From: Paul Cann
Sent: 19 June 2017 14:29
To: Planning.Responses
Subject: RE: Planning Consultation on LU/177/17/DOC

APPLICATION LU/177/17/DOC

Registered: 31-MAY-17
Site Address: Littlehampton Swimming & Sports Centre Sea Road
Littlehampton BN16 2NA

Description of Works: Application for approval of details reserved by condition imposed under planning permission LU/314/16/PL relating to condition No. 3 (Landscaping scheme), 4 (Habitat mitigation strategy), 6 (Foul & Surface water sewerage disposal), 10 (Details of plant & equipment), 14 (Details of kitchen extract system & type of cooking to be undertaken in the facility) & 15 (External lightings scheme)

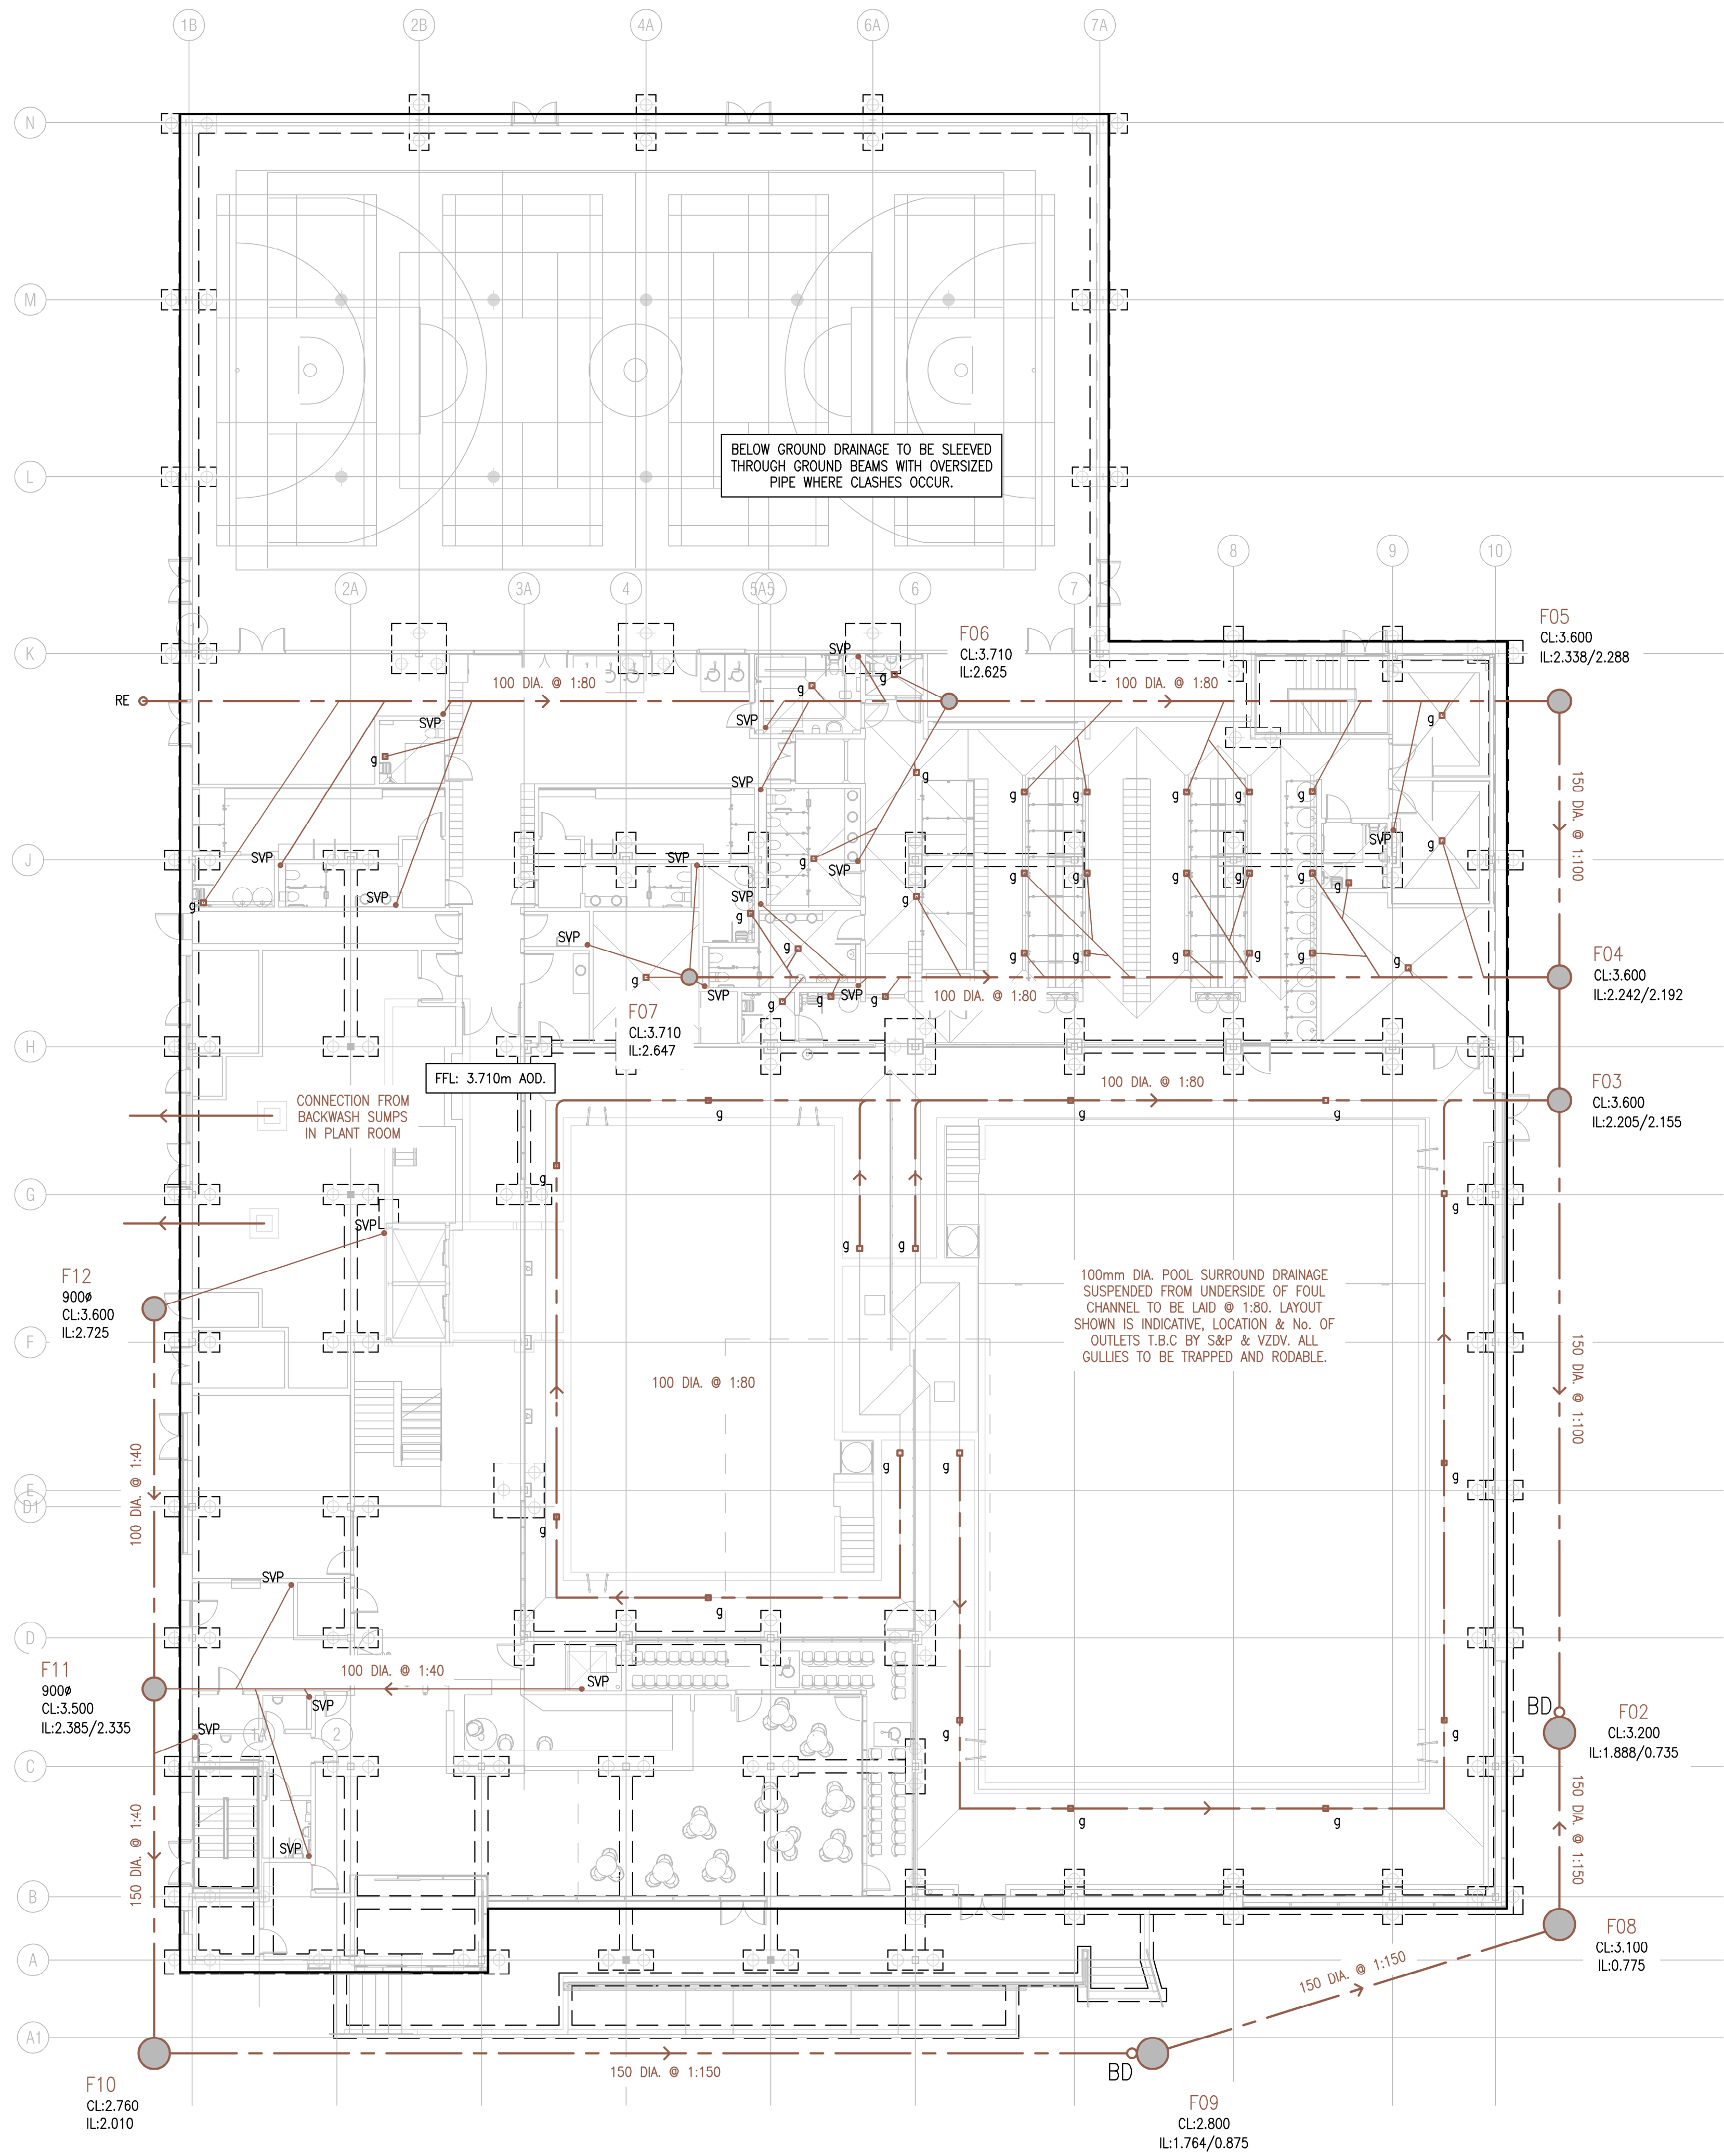
There is insufficient information in respect to the surface water drainage scheme, and the information provided has been superseded by later proposals. On that basis, the condition cannot be discharged at this time.
